Dear Inspectors

I request that you inspect the following locations, since I do not believe the removal of hedgerows or trees in this location is necessary; The area does not require special permission access as it is visible as well as adjacent to Thorpe Lane and Fleets Lane (Thorpe le Fallows, Sturton by Stow and Stow).

Drawing file: EN010133 / EN010133-000404-C6.4.8.16.7.1 Figure 8.16.7.1 Landscape and Ecology Mitigation and Enhancment Plan - Cottam 1_West_Option A_Sheet 2.pdf

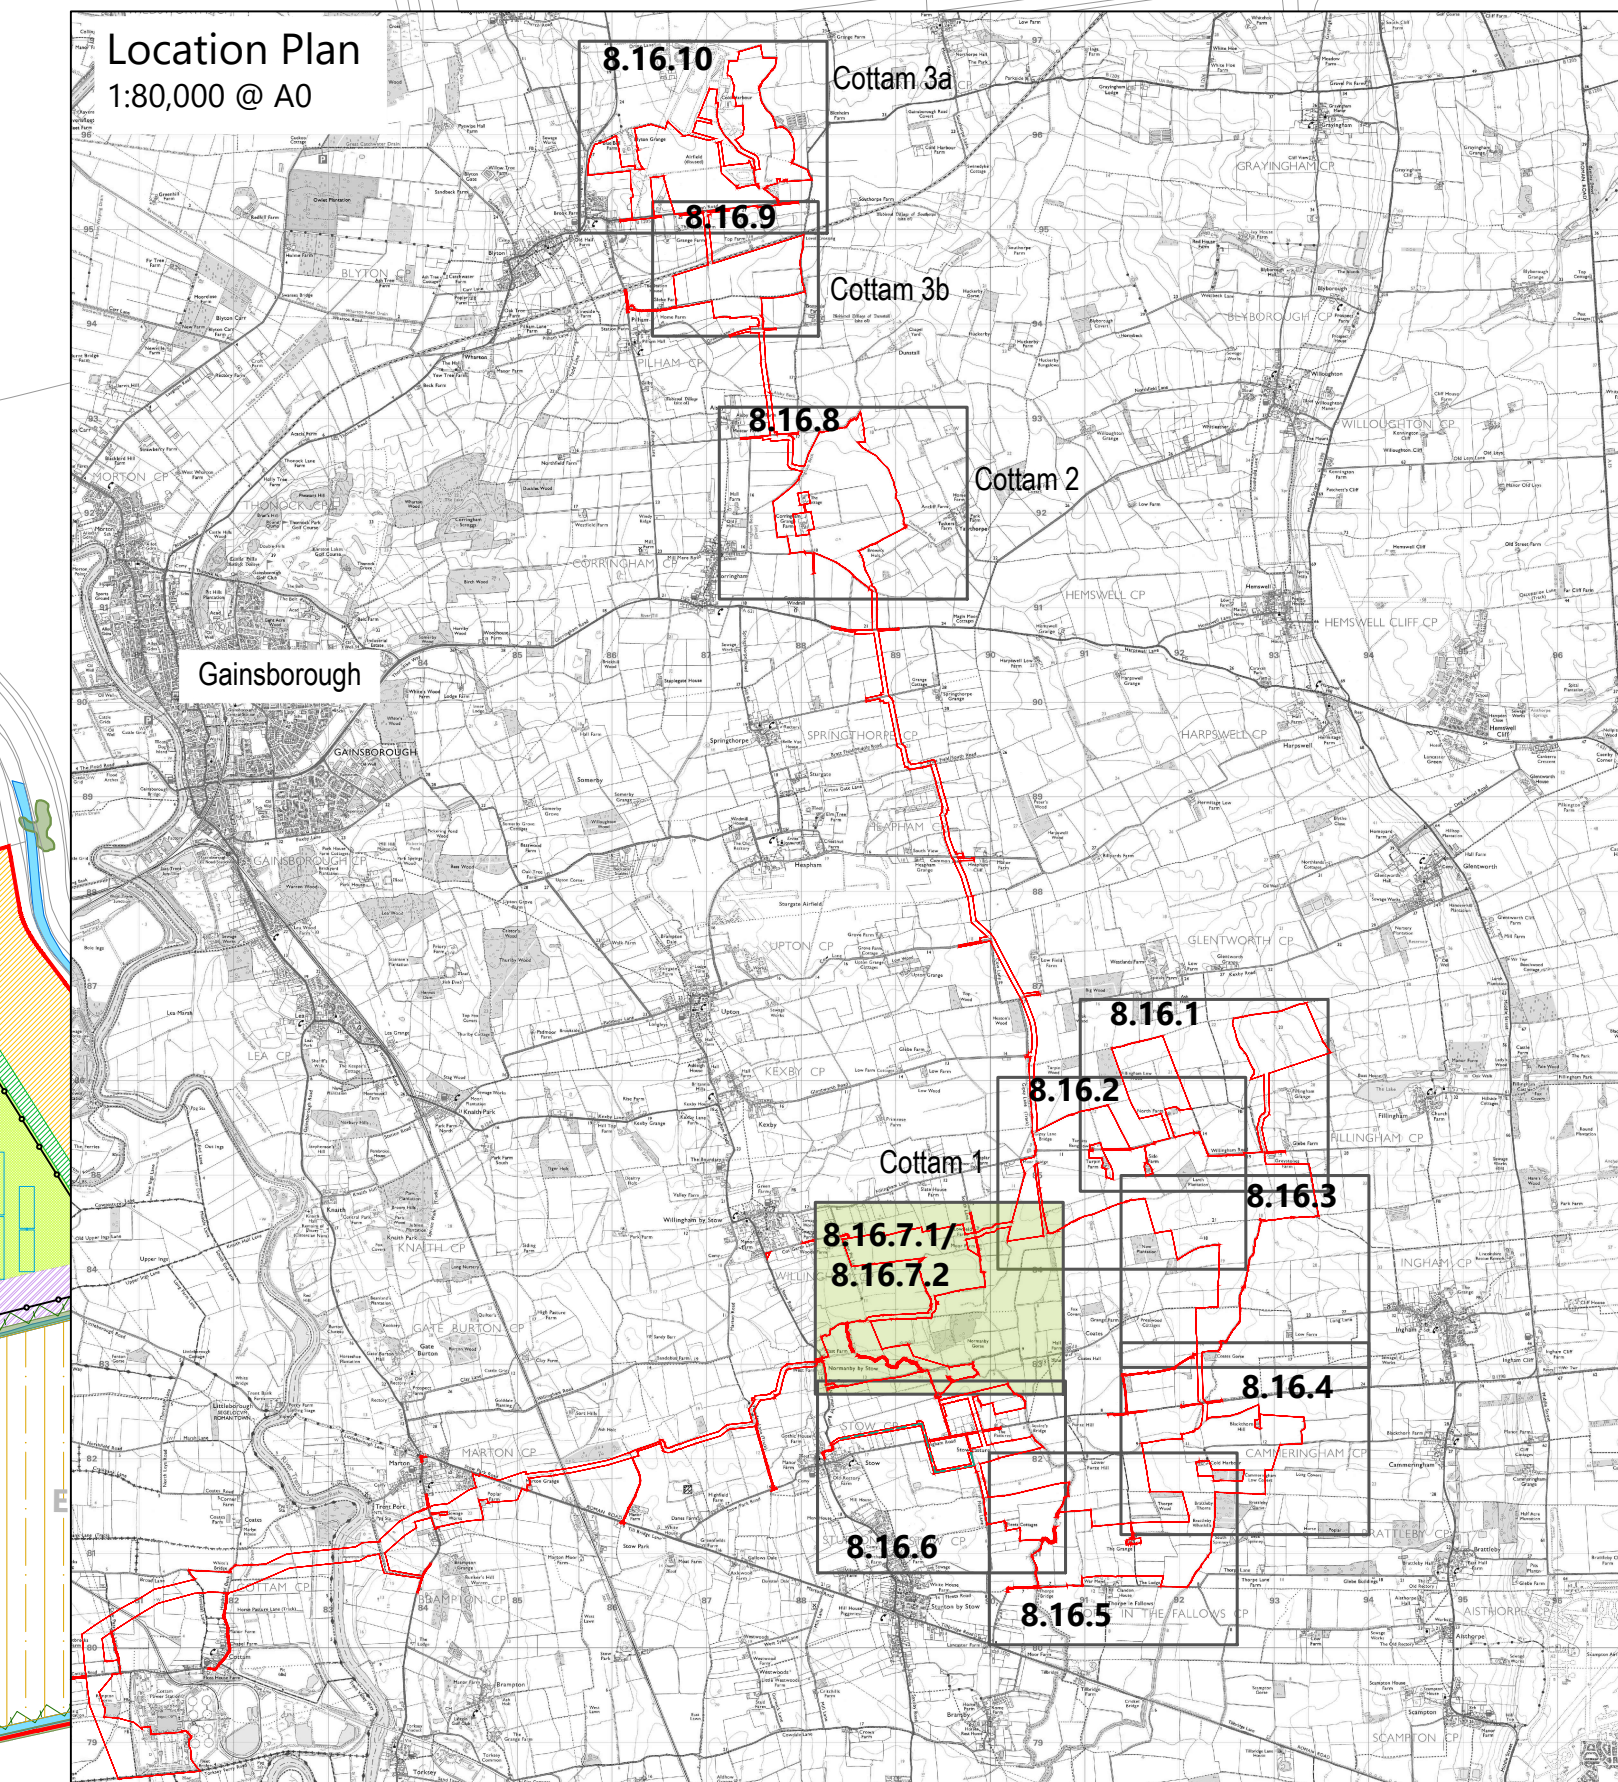
H275 Thorpe Lane – This hedge is located along the southern boundary of Thorpe Lane and is not, strictly, within the development area. The road is bounded by ditches each side. The highway is adequate for large agricultural machinery and large grain transport HGV's; The hedgerow is largely separated from the road by a wide grass verge and ditch and there is no apparent gain in removal of this particular hedgerow. Yellow Hammer, among other birds, nests in this particular hedge. The removal of this hedgerow will drastically alter the landscape character of the area. Please also note the stand of mature trees adjacent to the River Till. These should be protected as they not only form wildlife habitat but they also help with wind-break and water retention.

H278, H279, H280 The removal of these hedgerows will have significant visual impact from Sturton by Stow and for the residents of Fleets Lane Cottages. The hedges form a boundary to fields which will not be part of Cottam 1. The advantage of windbreak from the hedging to reduce soil erosion as well as absorbing surface water will be compromised, let alone the disaster for wildlife which relies on this habitat. There appears to be no pertinent reason for removal of these hedgerows.
